KIRKLEES METROPOLITAN COUNCIL INVESTMENT & REGENERATION SERVICE

Reference No:	2026/62/90656/E
Site Address:	6, Nelson Street, Dewsbury, WF13 1NA
Description:	Replacement of specified external doors and windows with like-for-like units (Listed Building within a Conservation Area)
Recommending Officer:	Faiza Bano

Officer Report – 2026/90656

Door Elevations [1:20]

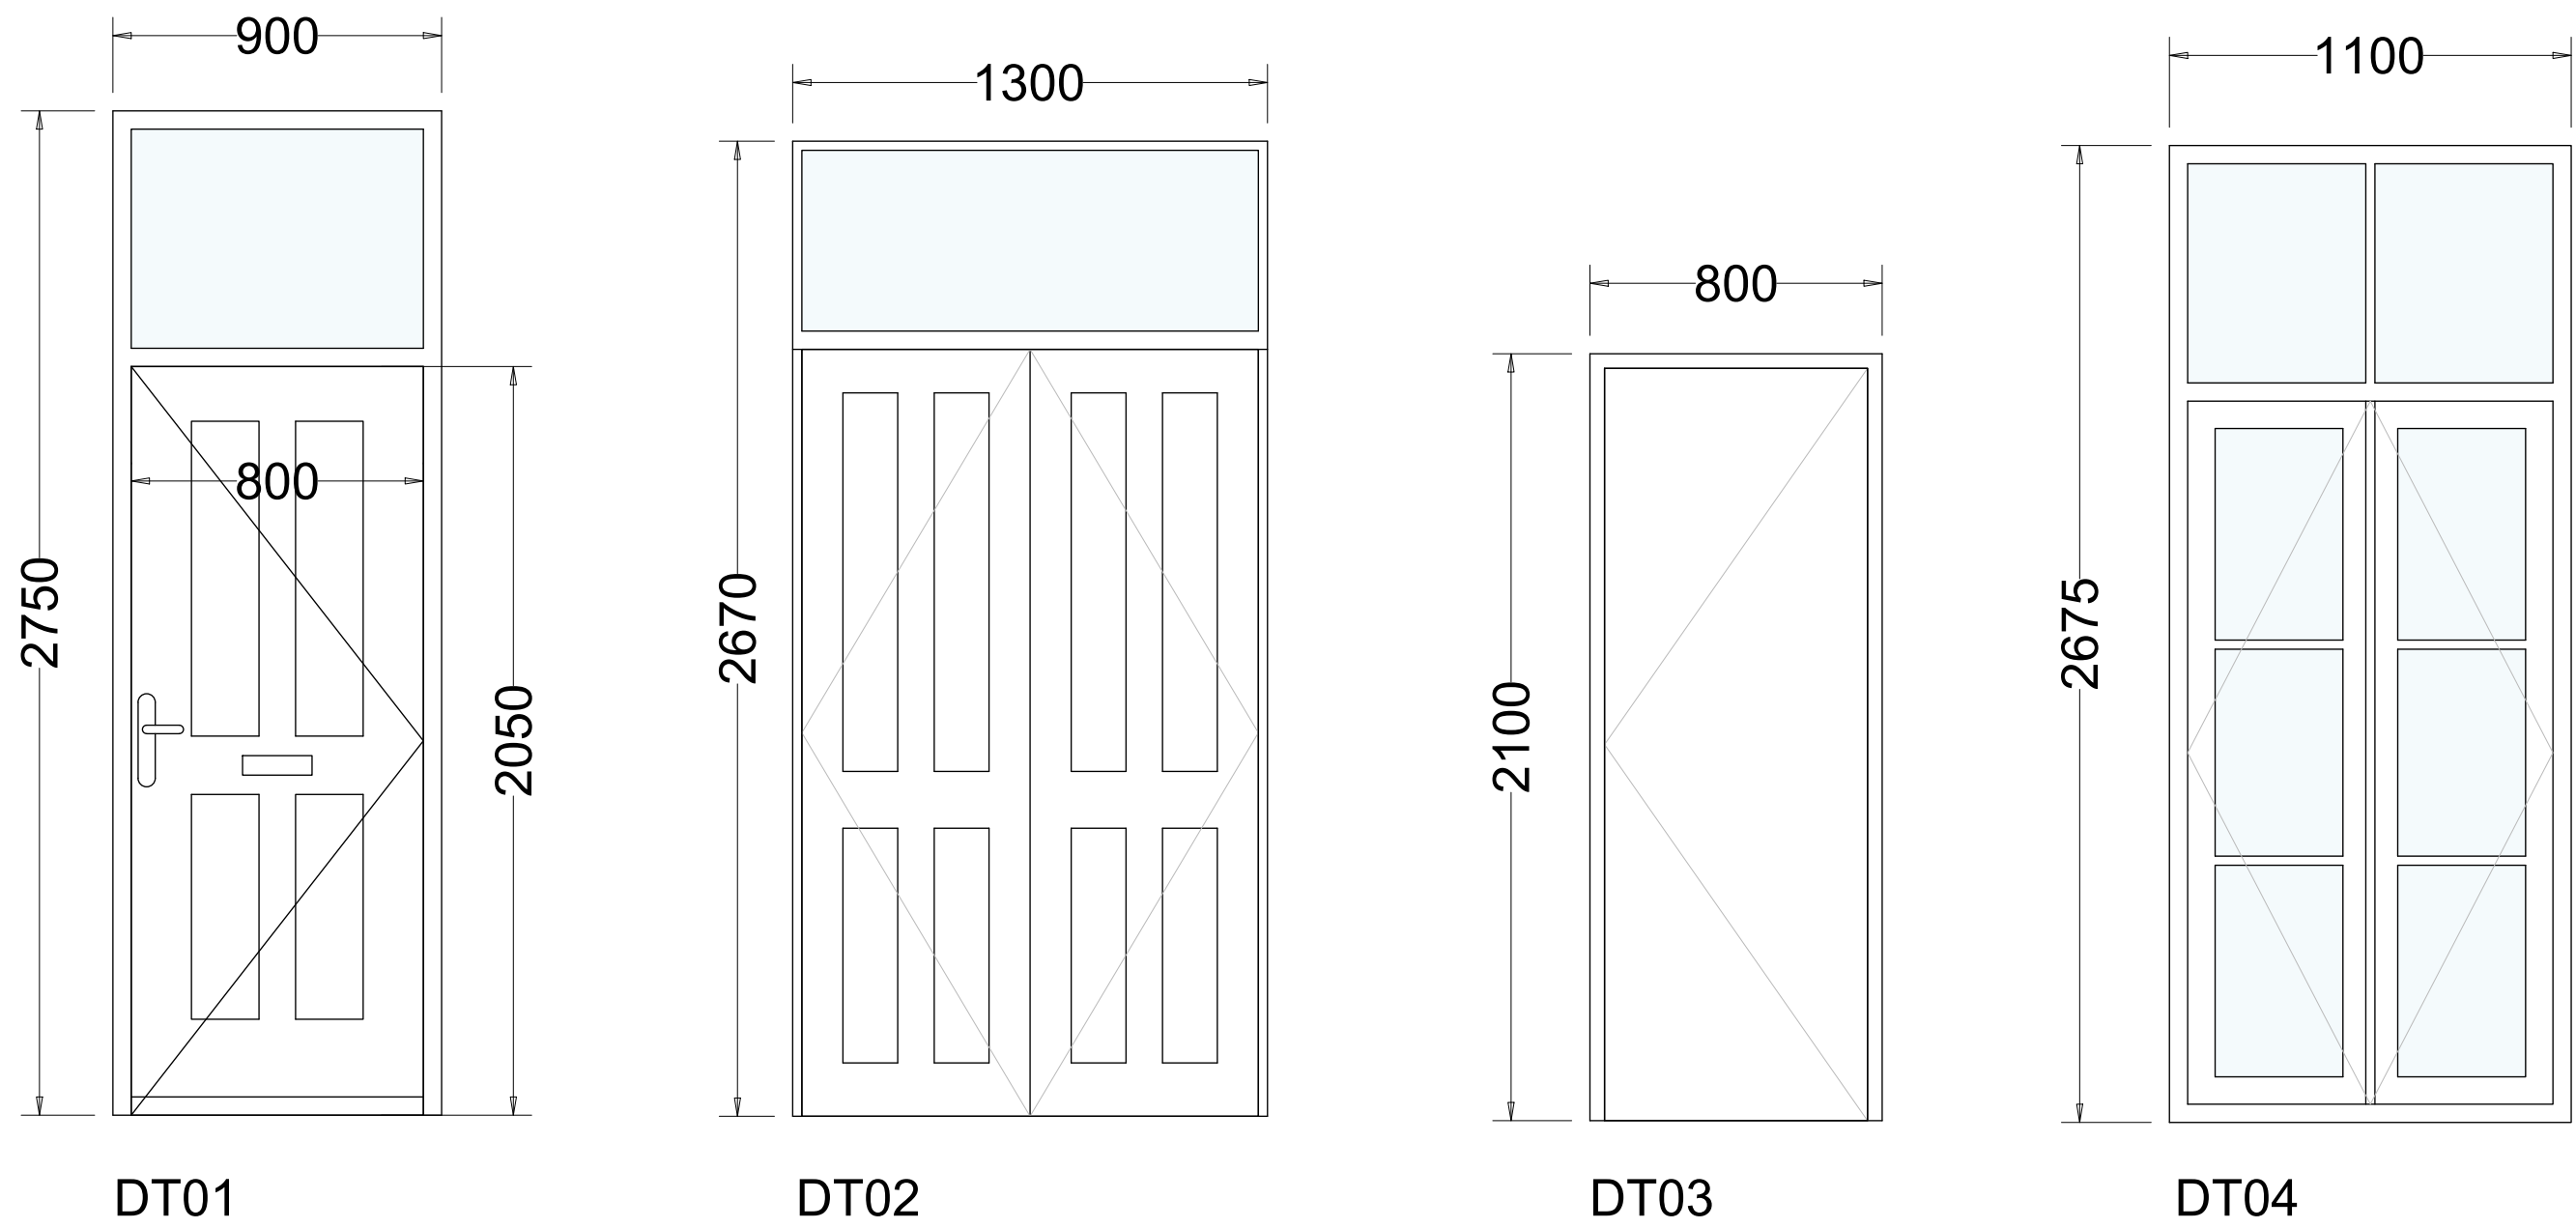
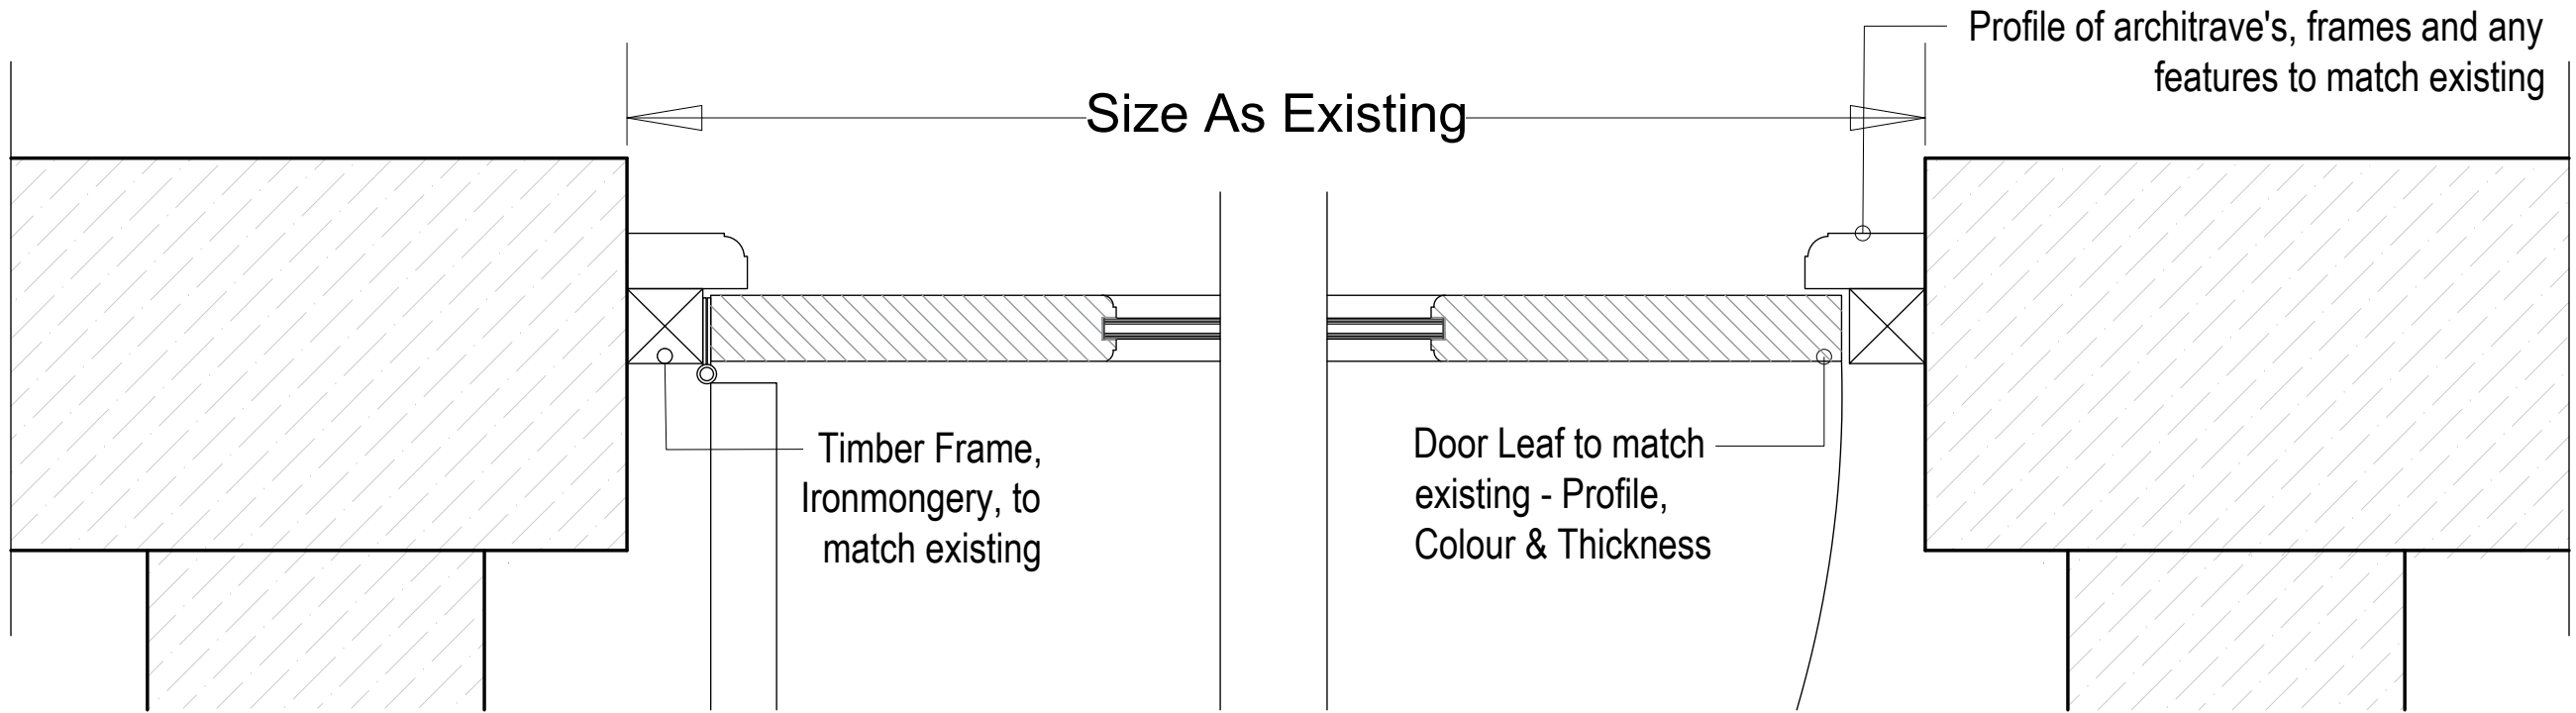
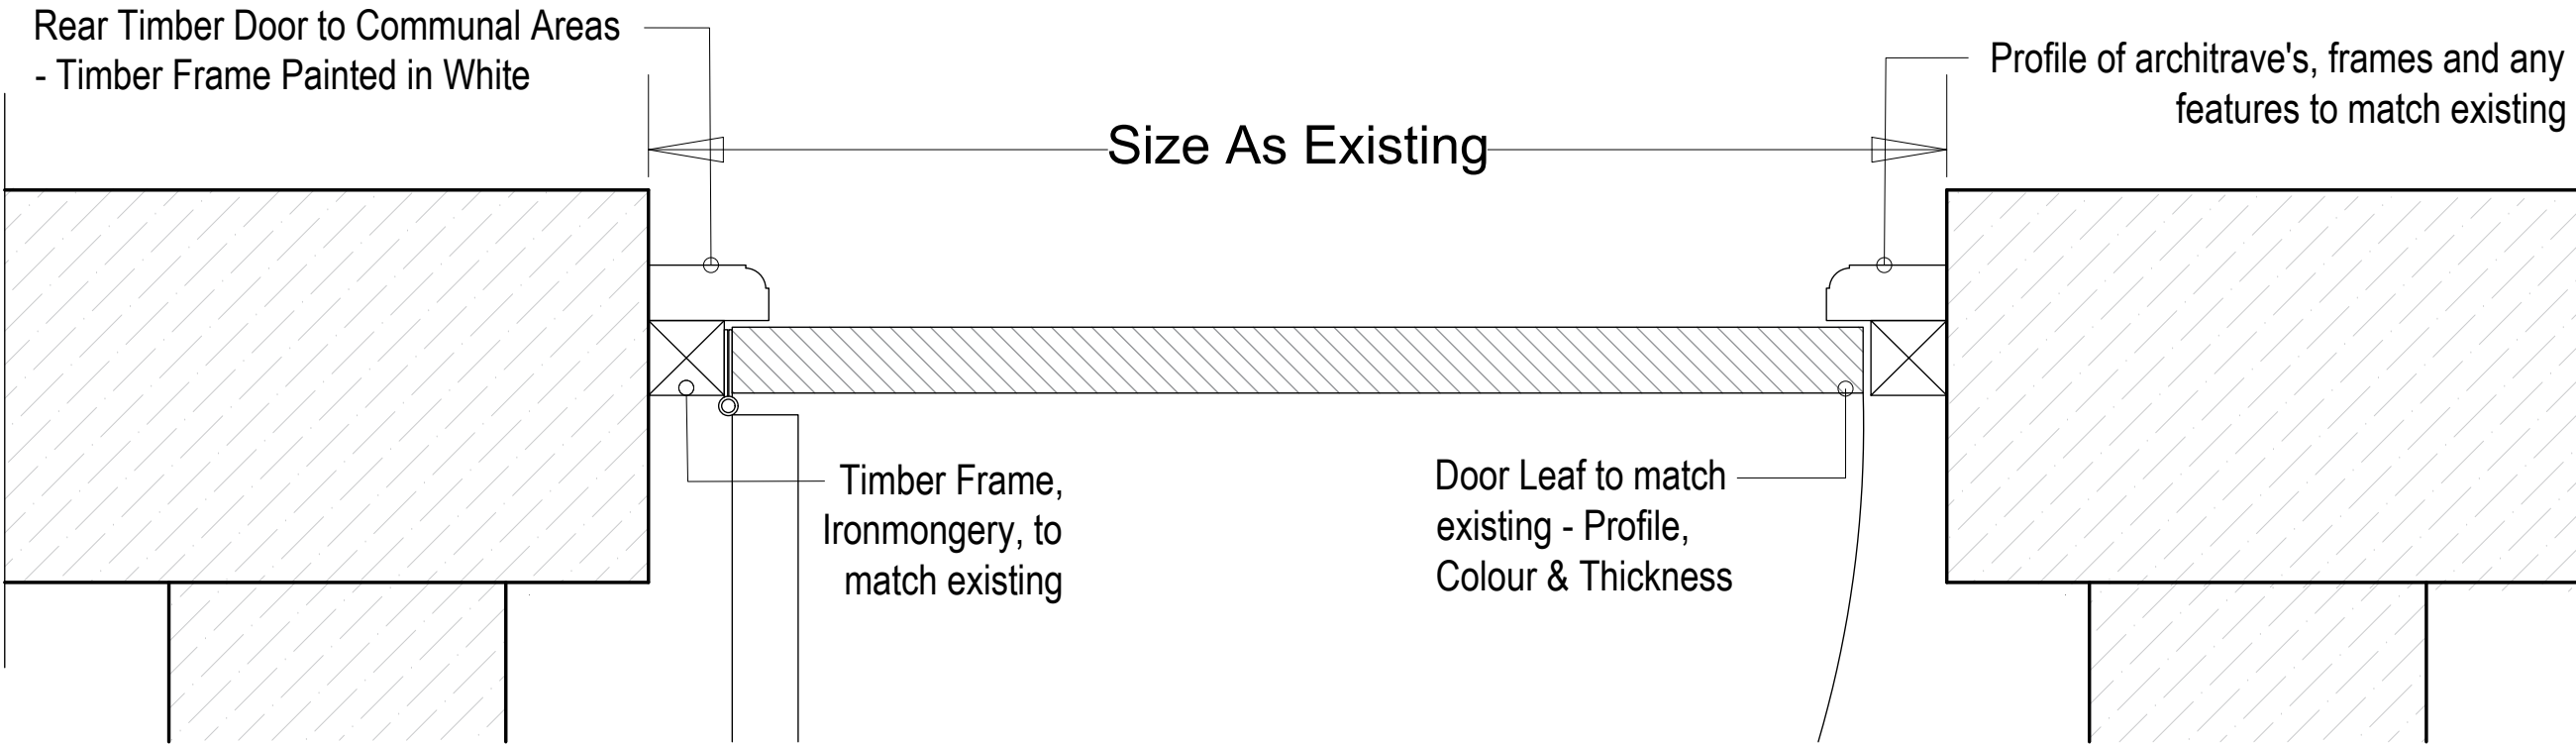
4. All external doors shall be constructed from timber (not composite) to match existing, with no visible tricklevents, and the frames shall be set back in the reveal with 75-100mm or to match existing and shall not be fitted flush with

the external wall.
